Planning Application ref: P/07/11
New House at 52 East Front Road, Pagham
Letter of Objection

In my position as Committee member of the Pagham Beach Residents Association delegated to consider planning matters I write to comment on the above application.

Project	52 EAST FRONT ROAD, PAGHAM, BOGNOR REGIS WEST SUSSEX PO21 4ST	Drawn	sk	Project	126
For	Mr and Mrs Eysers	Scale	1:100 @ A3		
Title	GROUND FLOOR - PROPOSED	Date	25.10.2011	Revision	d
				Drawing No.	P 01

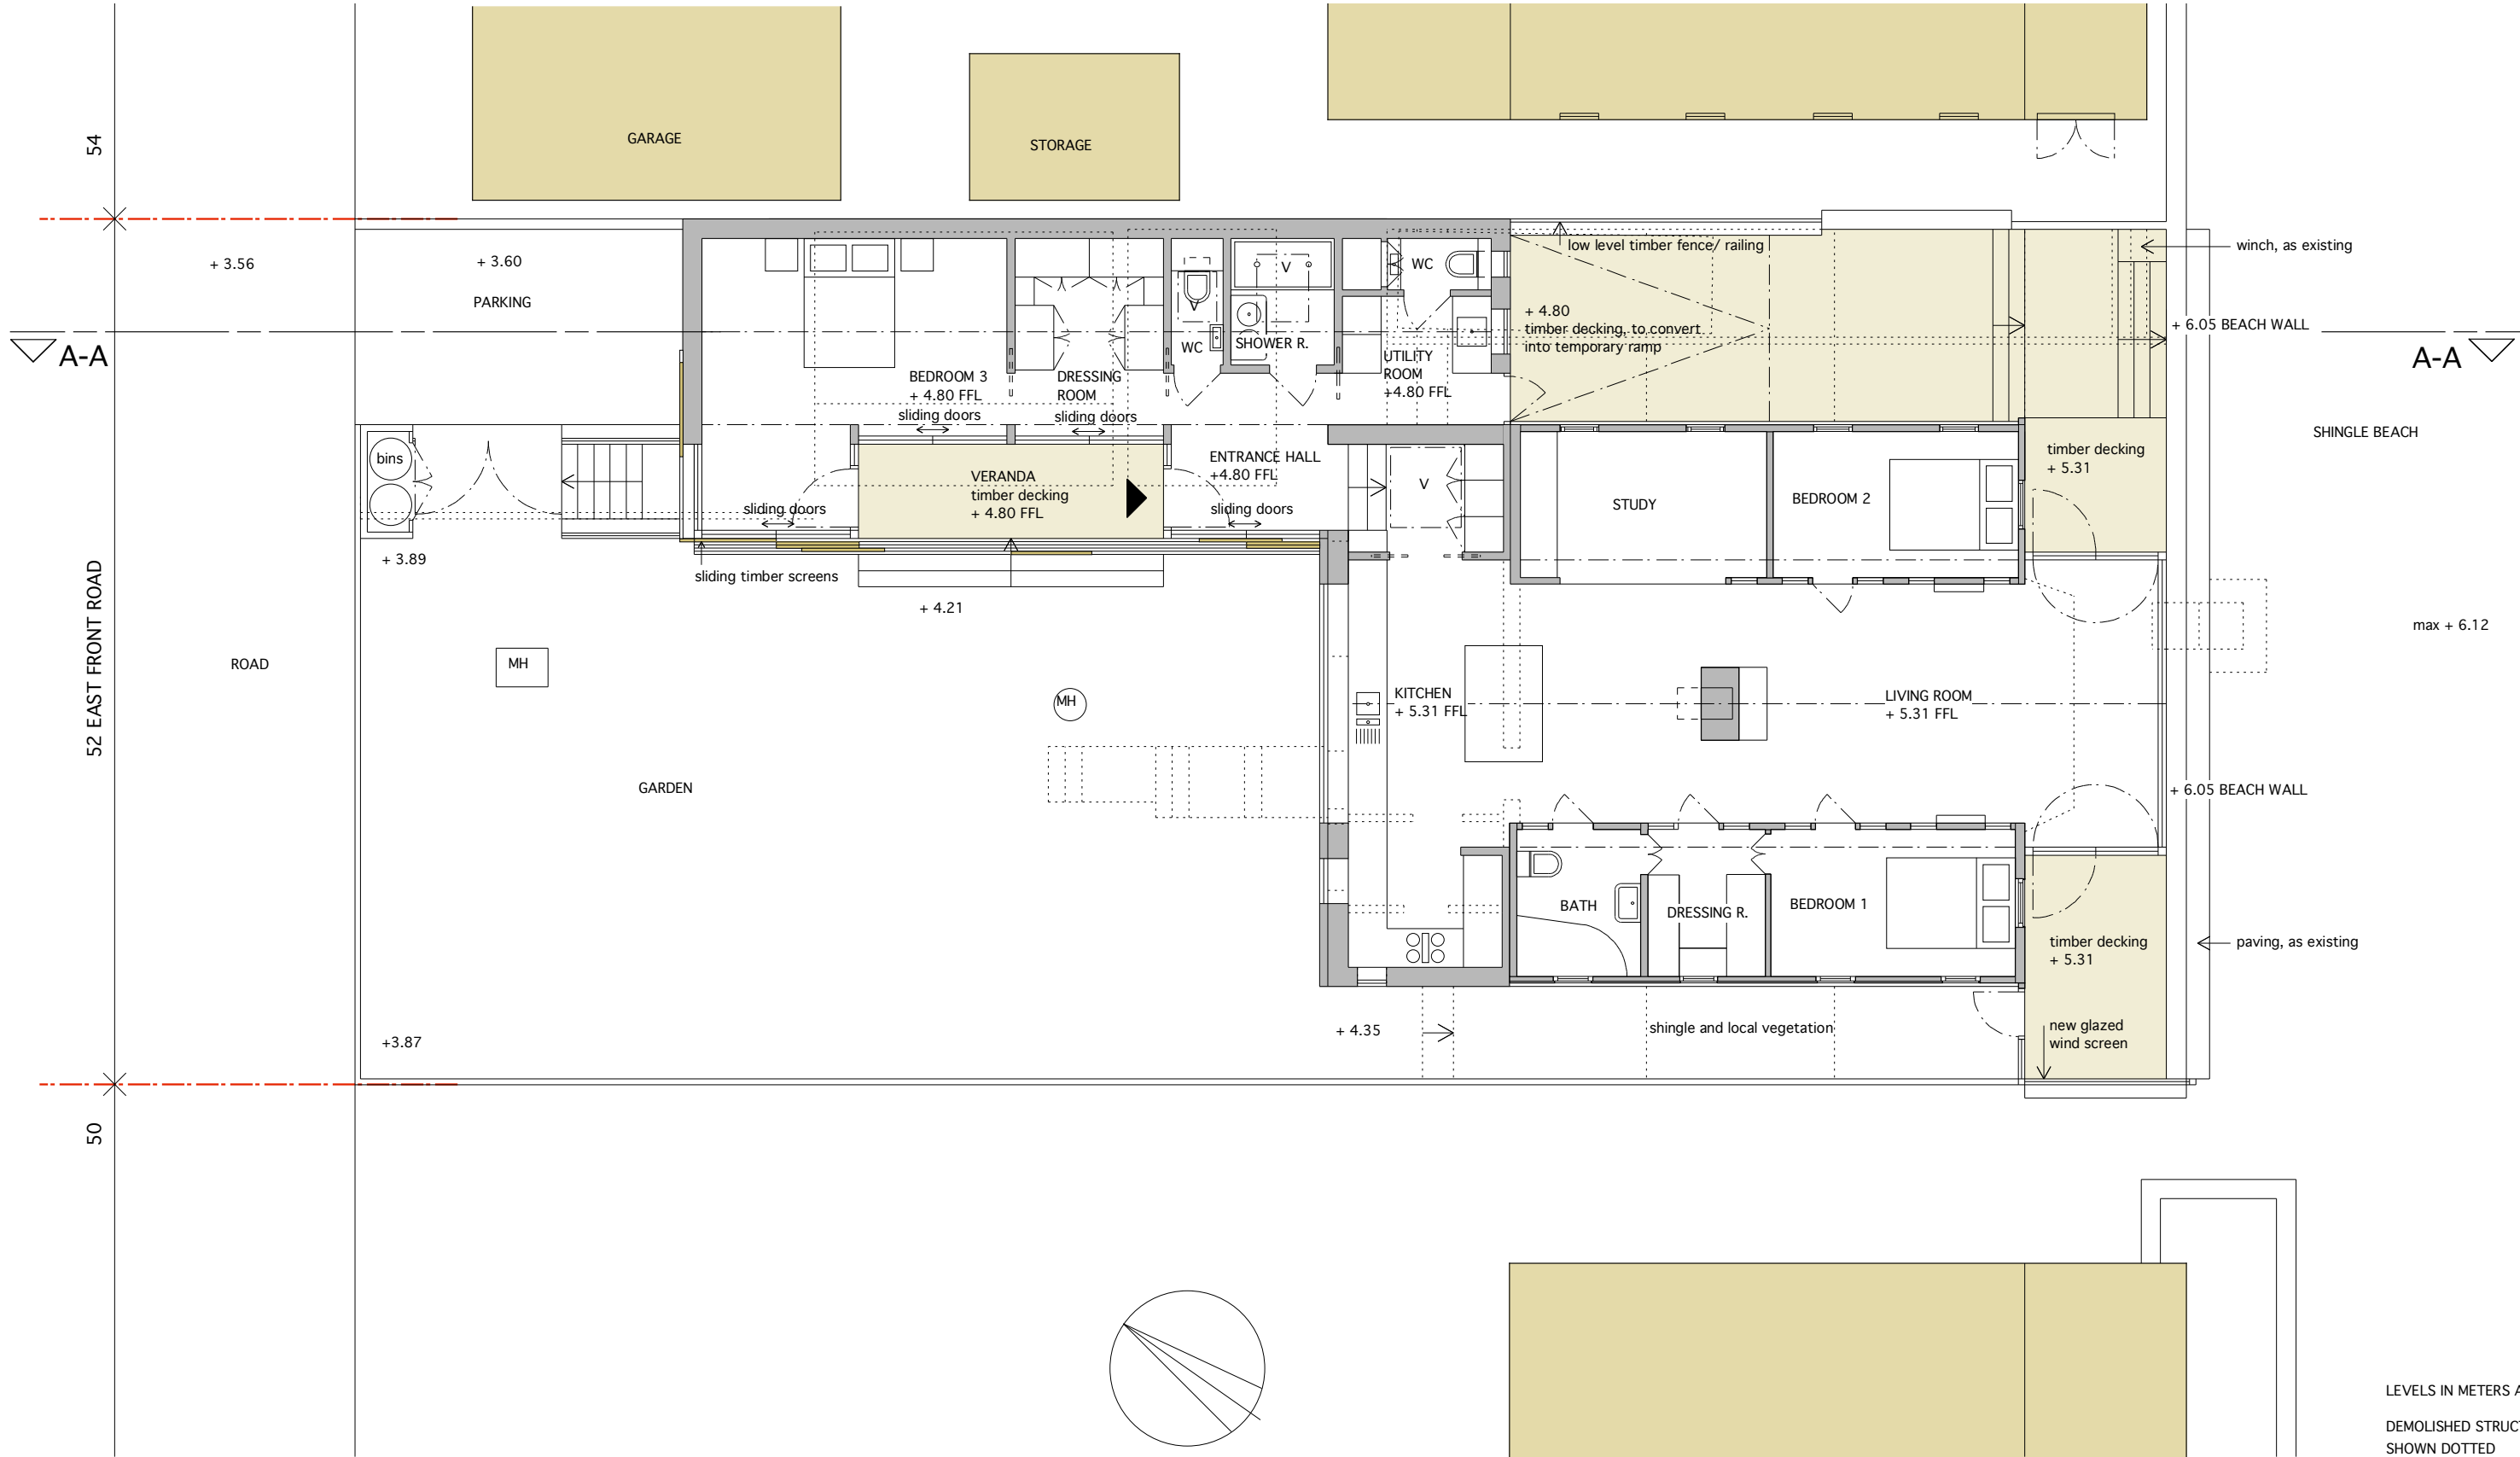
1. **The extension to the house lies ~~on~~ on the boundary to the adjoining property,** where development on adjacent sites on the Beach Estate usually allows approximately 1m clearance from the boundary to avoid shading and overcroding as well as allowing the property to be maintained from the owners land
2. **The extension is a two storey construction whereas the Village Design Statement prescribes a single storey limit on development.** Although this ~~is~~ ~~is~~ requirement has been transgressed in the past this is damaging to the Estate and should be resisted at all costs.
3. **The 'undercroft' below the extension implies a dangerous and potentially damaging construction sequence.** The angle of repose of the beach shingle is typically 30° so the excavation to form this would inevitably cause the collapse of surrounding structures.
